CITY OF ALBUQUERQUE

Re: **Platinum Apartments**
 4100 Silver Ave., SE
 Certificate of Occupancy – Transportation Development
 Engineer's/Architect's Stamp dated 2-3-14 (K17-D108)
 Certification dated 7-22-15

Re: **Sierra Platinum Apartments**
4100 Silver Ave NE
Request for Permanent C.O. – Not Accepted
Engineer's Stamp dated: 5-12-14 (K17D108)
Certification dated: 7-17-15

RE: **Sierra Platinum Apartments - 4100 Silver Ave, NE**
Grading & Drainage Plan for Building Permit
Engineer's Stamp Date 3-20-2014 (H17/D108)

GRADING PLAN

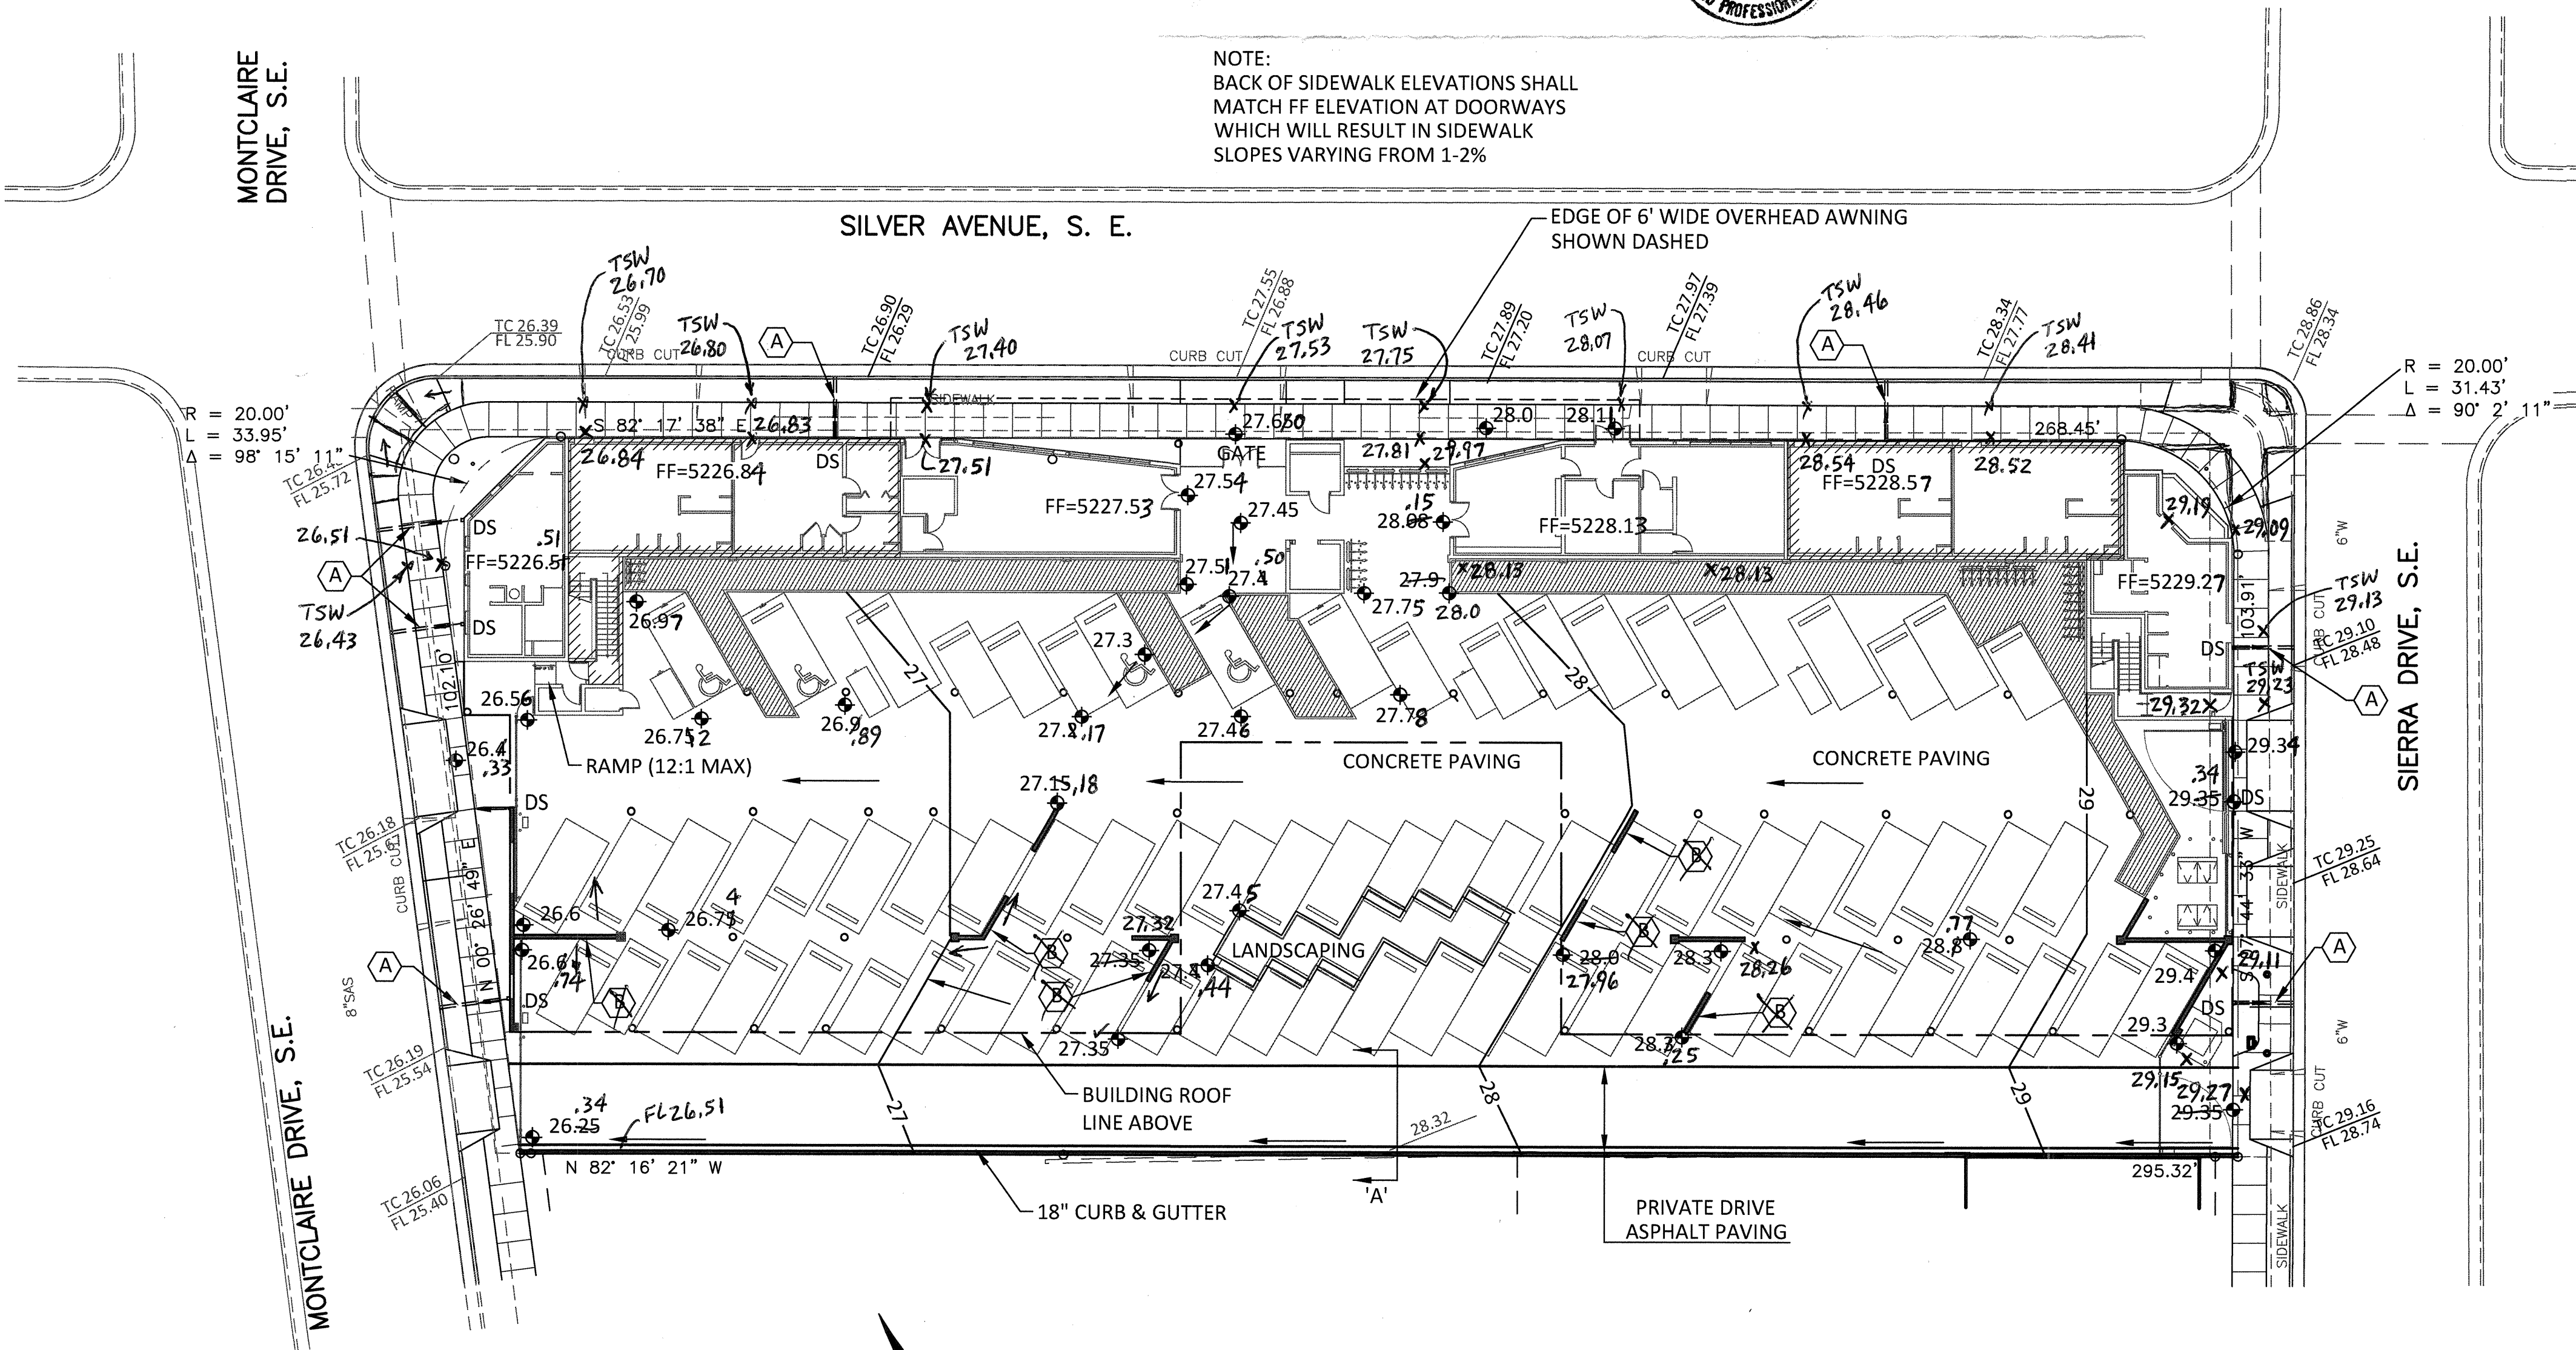
- ✓ 1. Show spot elevations at Top of drive pads along Sierra Drive to ensure FL is at a lower elevation.
- ✓ 2. Indicate the edge of awning on the North side of building, and note that it drips into the landscape strip.
3. Indicate that the Back of Sidewalk matches FF elevation and the sidewalk slope varies from the standard 2% slope.
4. Indicate the TC elev. on the North side of bldg. near the entrance.

GRADING PLAN

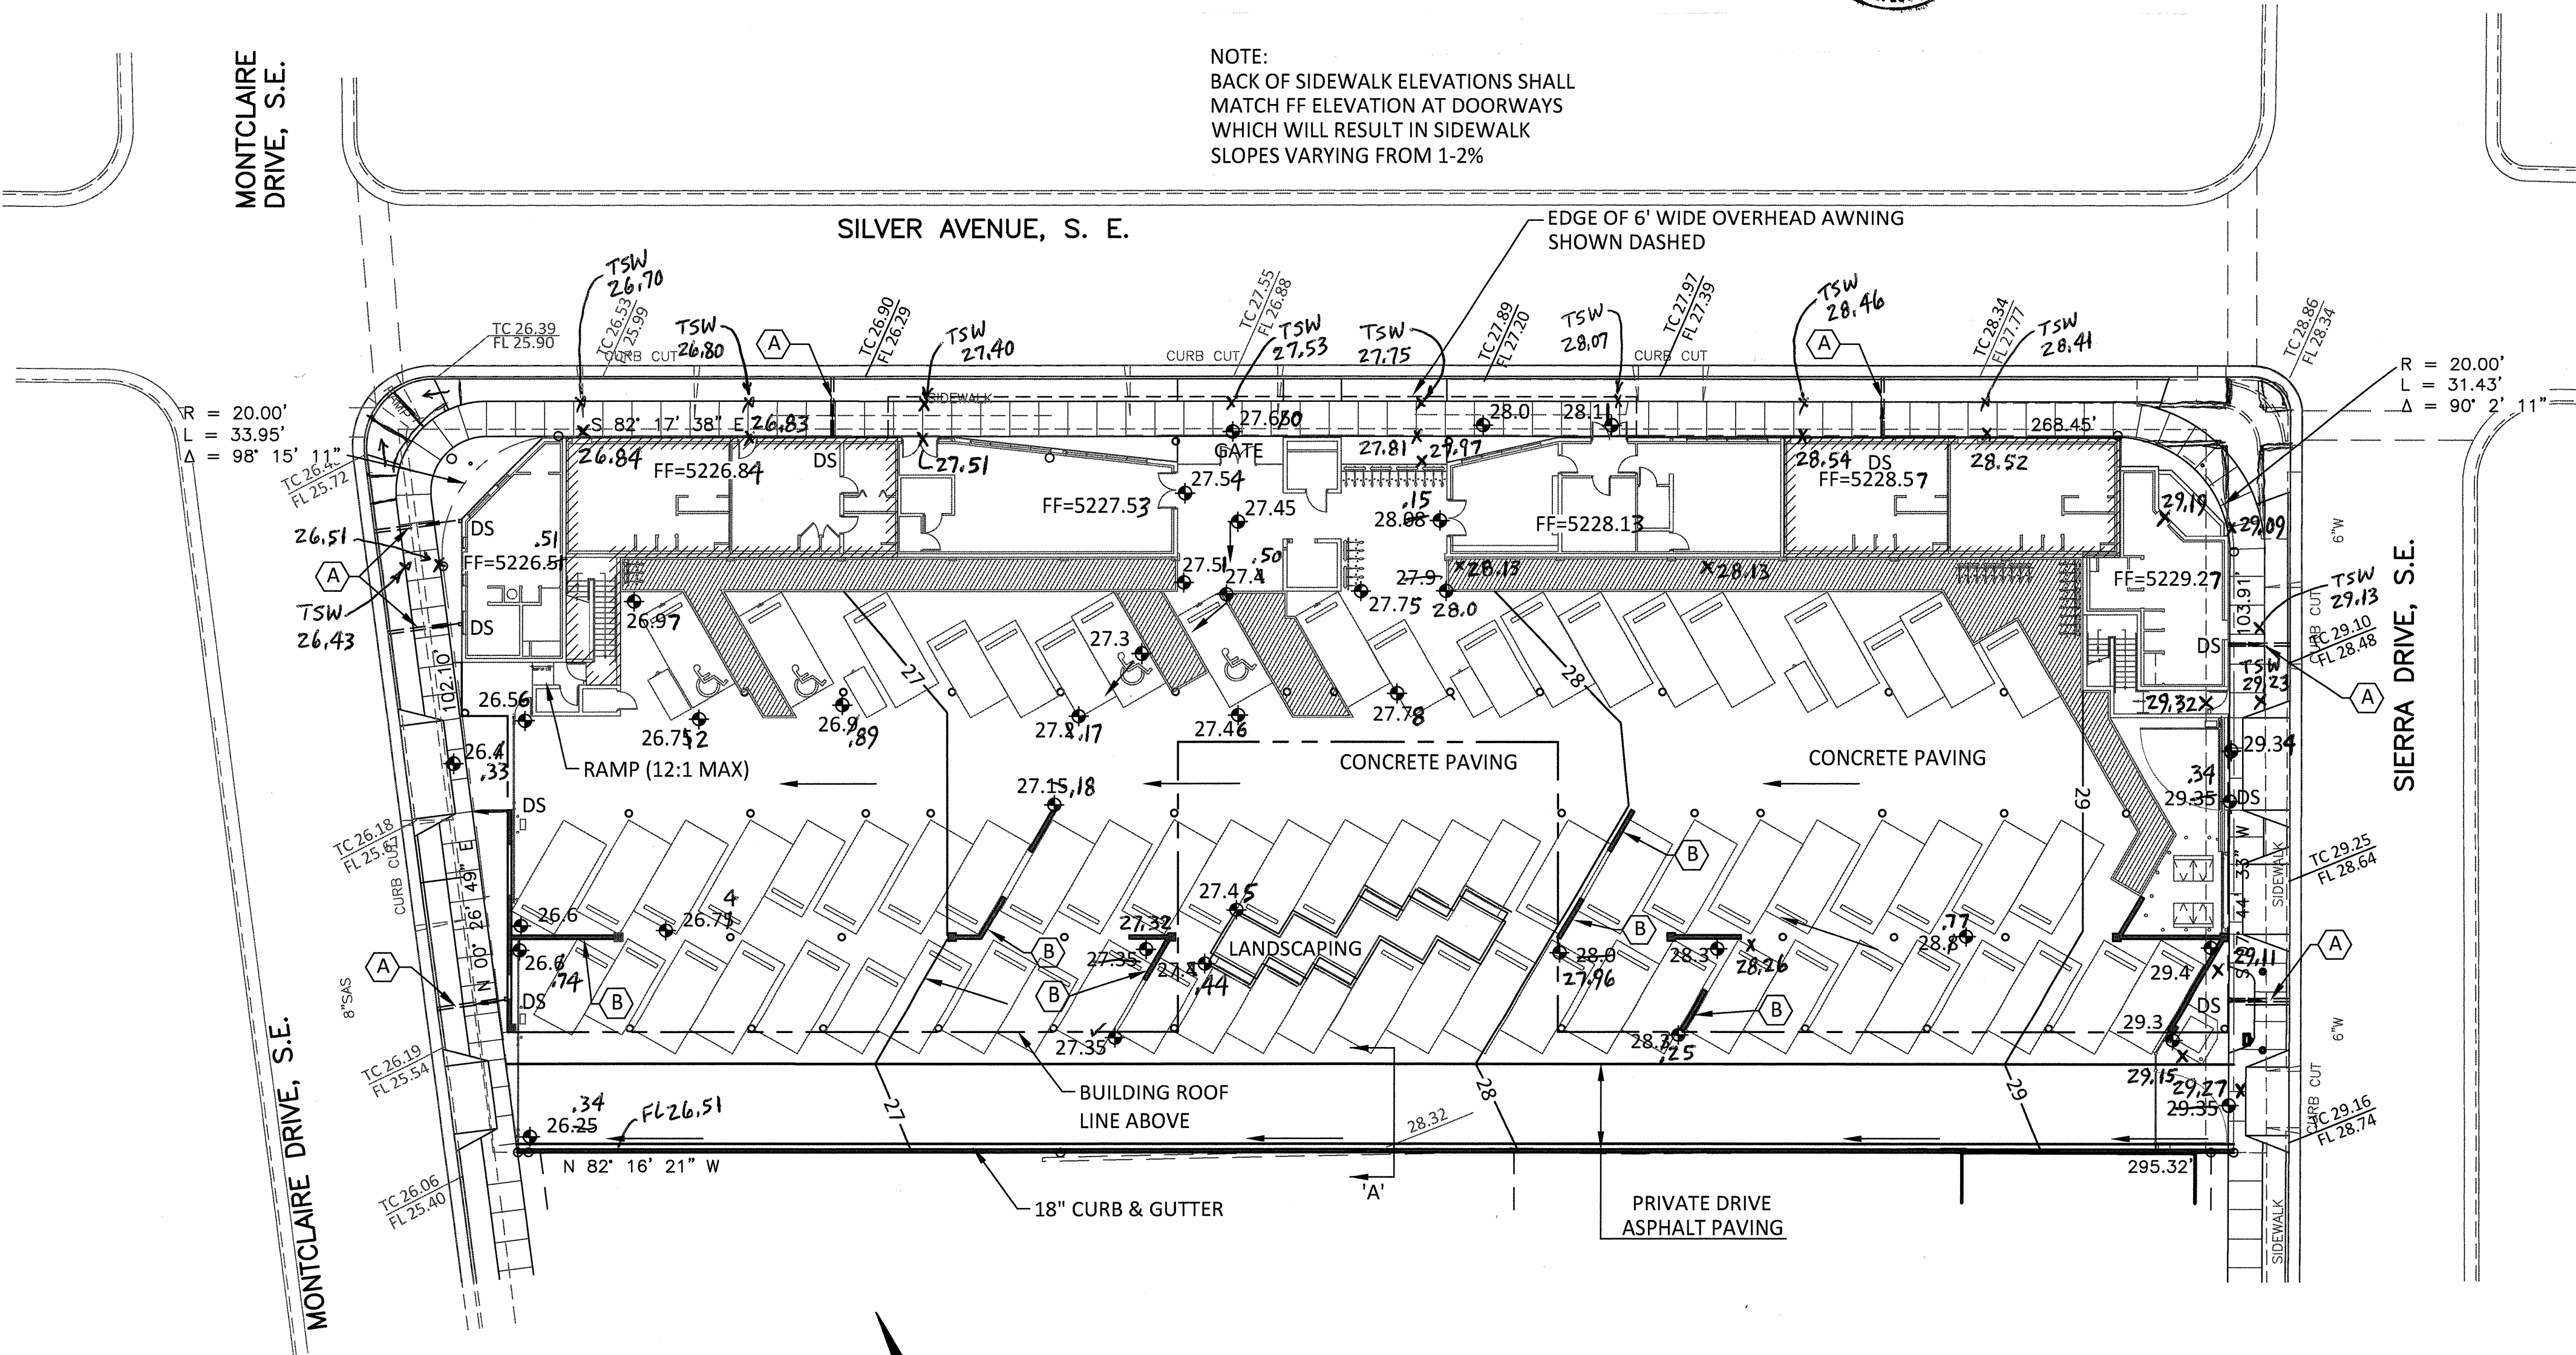
Based on the Certification received on 7/20/2015, the Sierra Platinum Apartments are not acceptable for release of Certificate of Occupancy by Hydrology. The sidewalk culverts were not approved by Jason Rodriguez and the cutouts in the walls were not provided. In the new plan being submitted provide roof flows and new calculations for the site.

A1 TRAFFIC CIRCULATION DIMENSION PLAN
1"=20'-0"

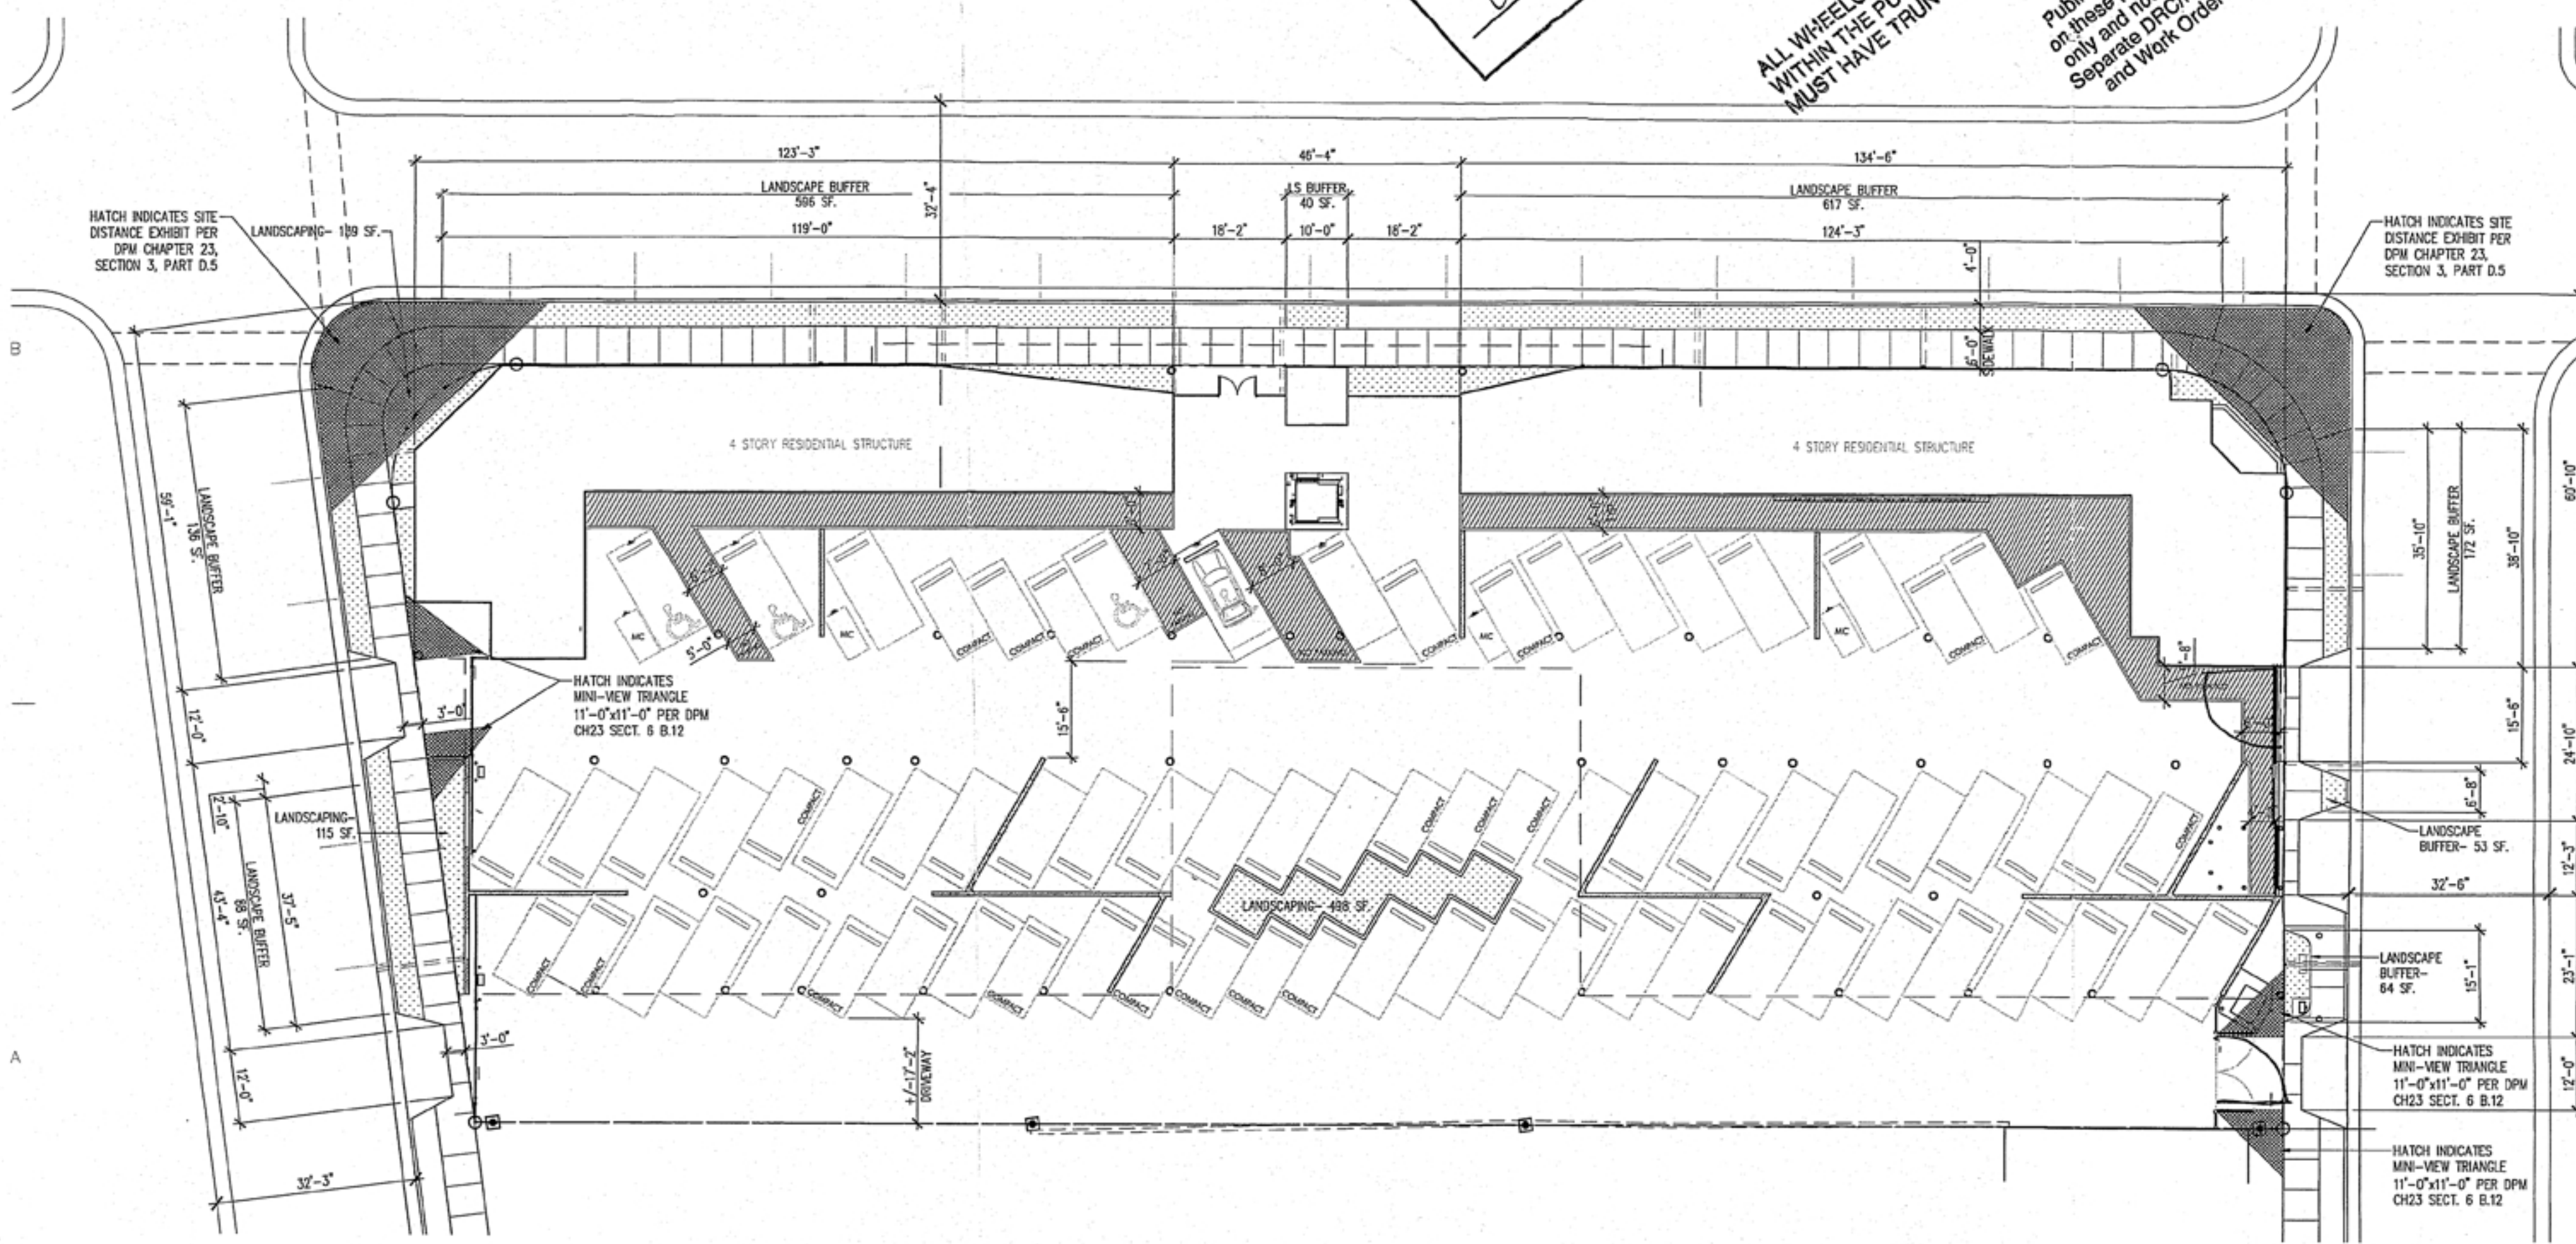
1. Demonstrate the proposed building location will not interfere with the sight distance of the intersection. Please provide a sight distance exhibit (see the *Development Process Manual, Chapter 23, Section 3, Part D.5 Intersection Sight Distance*).

2. Demonstrate the "mini clear sight triangle" is maintained at proposed driveways (see *DPM Ch 23, Section 6 Curb Cuts and Driveways, part B.12 Visibility for Driveways*).
3. Please add the following note: "Landscaping and signing will not interfere with clear sight requirements. Therefore, signs, walls, trees, and shrubbery between 3 and 8 feet tall (as measured from the gutter pan) will not be acceptable in this area."
4. On-Street parking Allowance to fulfill zoning's parking requirement must be approved by the Traffic Engineer, Kristal Metro prior to TCL approval. The application requires 15 working days. On-street parking allowances are based on available parking along public right-of-ways fronting the

- property. The development will only be granted 50% of available street parking.
5. Recommend maintaining existing intersection corner layouts to avoid a COA Work Order to patch street asphalt.
 6. Clarify Key Note 31 (for example, remove existing infrastructure and replace with curb & gutter, sidewalk or landscape buffer as indicated).
 7. Remove Key Note 27; this is COA Street Maintenance jurisdiction.
 8. Please check the dates submitted; I believe the architect's date is incorrect.
 9. Please correct minor labeling errors discussed over the phone with Ken Myers. The submitted site plan with mark-ups is available to borrow. Please return this site plan with next submittal.
